Re: Hazel Dean, Charnwood Road, Bersted PO22 9DU

Ref BE/68/20/HH

I refer to your email dated 15.7.20 raising the following comments:

front
proposed elevations
SCALE 1:100

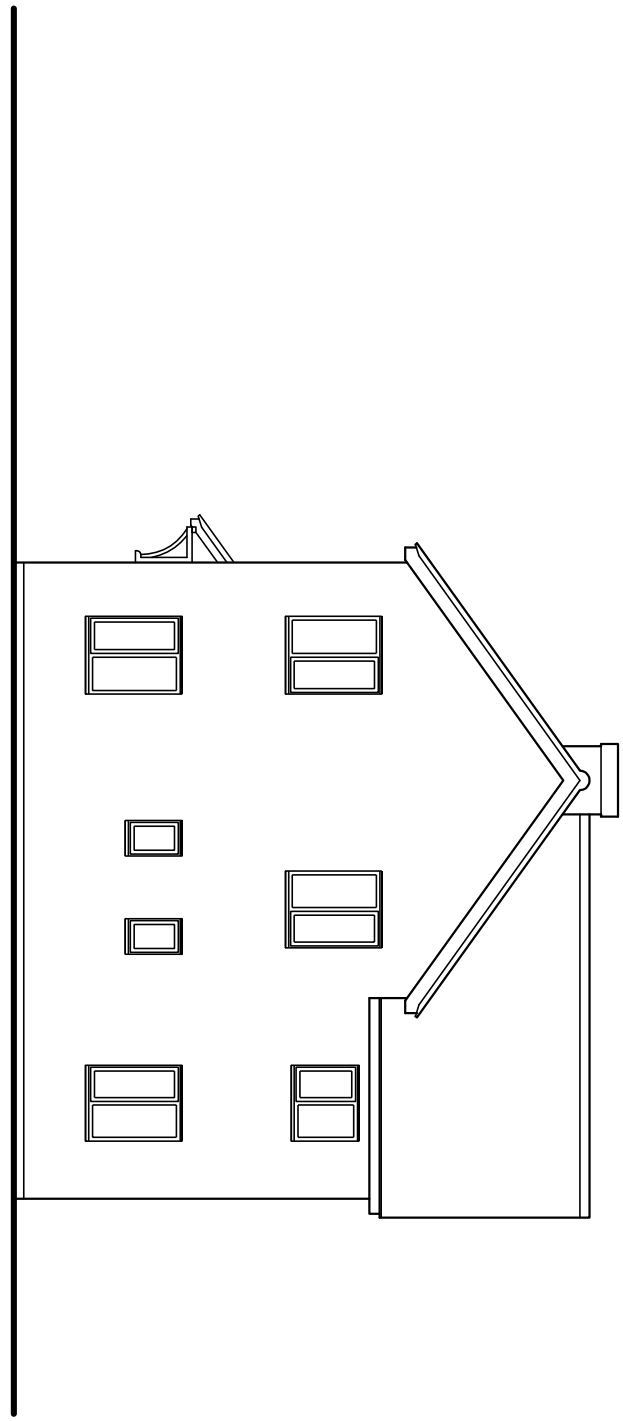
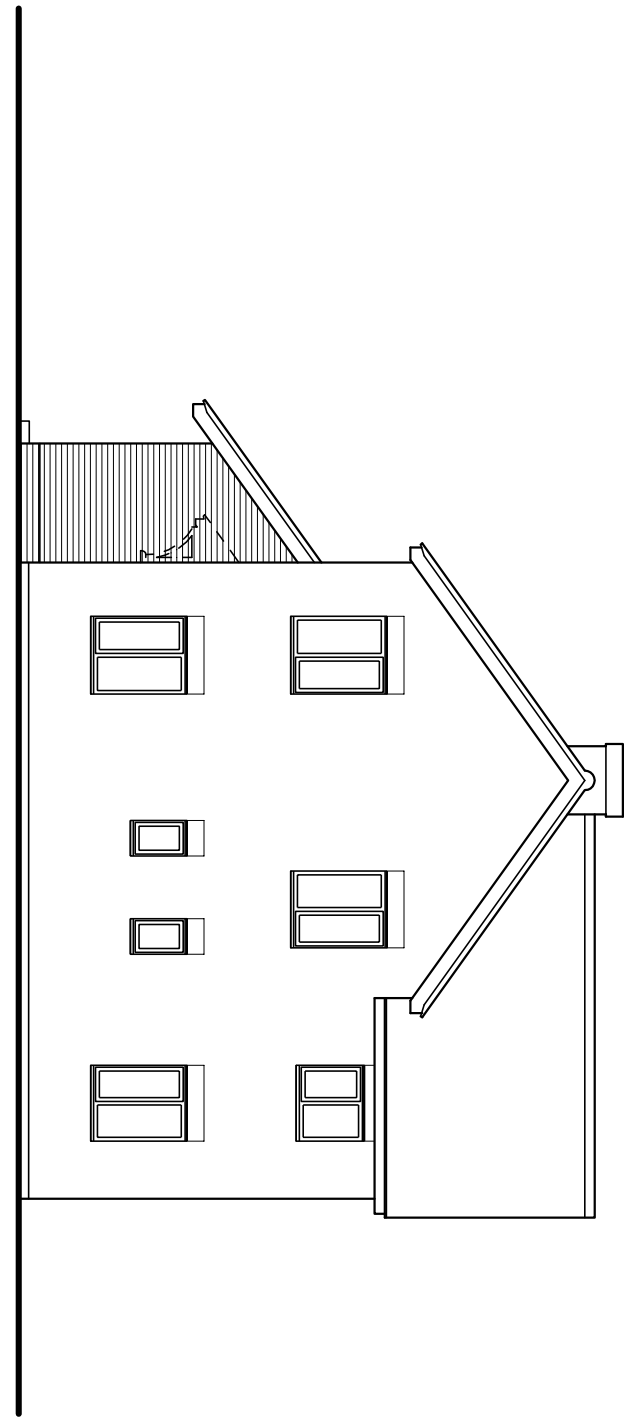
1. Amended description to 'porch to front', submitted description single storey addition. To be precise a porch is separated from a dwelling by a door(s) whereas an addition/extension creates a larger room(s). In this instance the

addition proposed enlarges the existing hall area, ie not a porch. Perhaps a accurate description would be 'single storey addition to front' please confirm your acceptance.

site plan

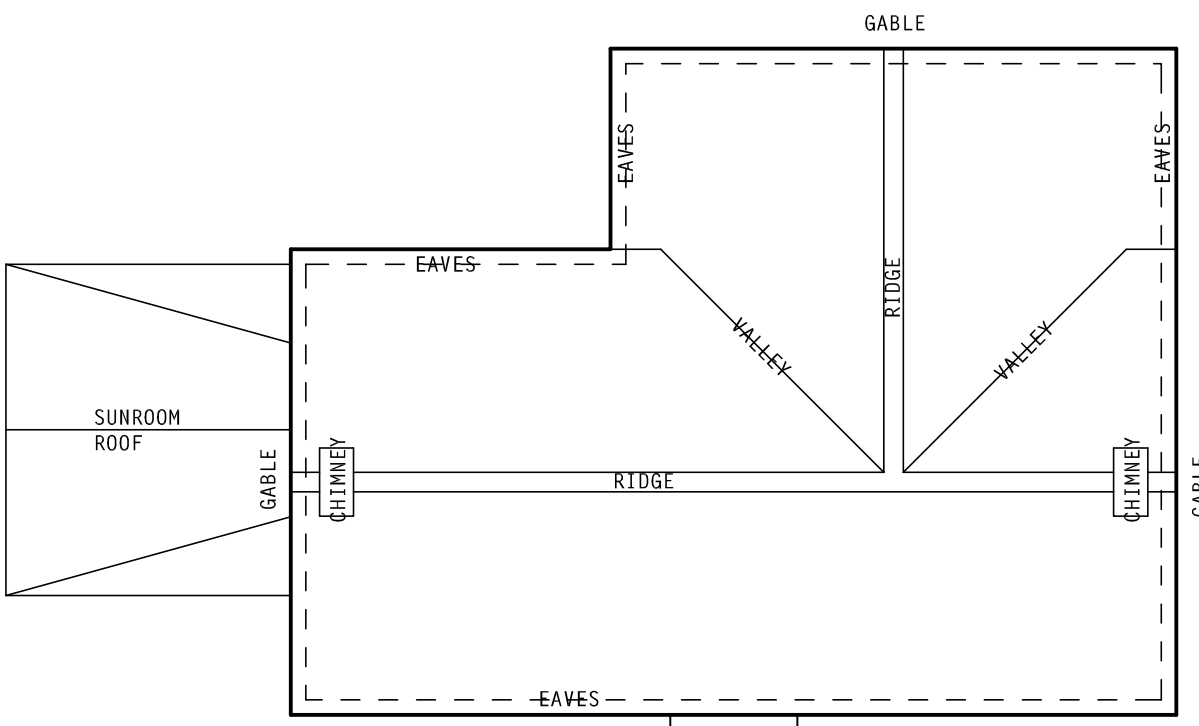
2. 'You are required to have dimensions from the proposed extension to all site boundaries, please amend'. The site is irregular in shape and covers a large area, about the size of a small field. The site plan indicates two dimensions from the property to boundaries, 17.533m & 13.021m, which I trust is adequate. If not, could you please advise which points on the boundaries you would prefer the dimension to.
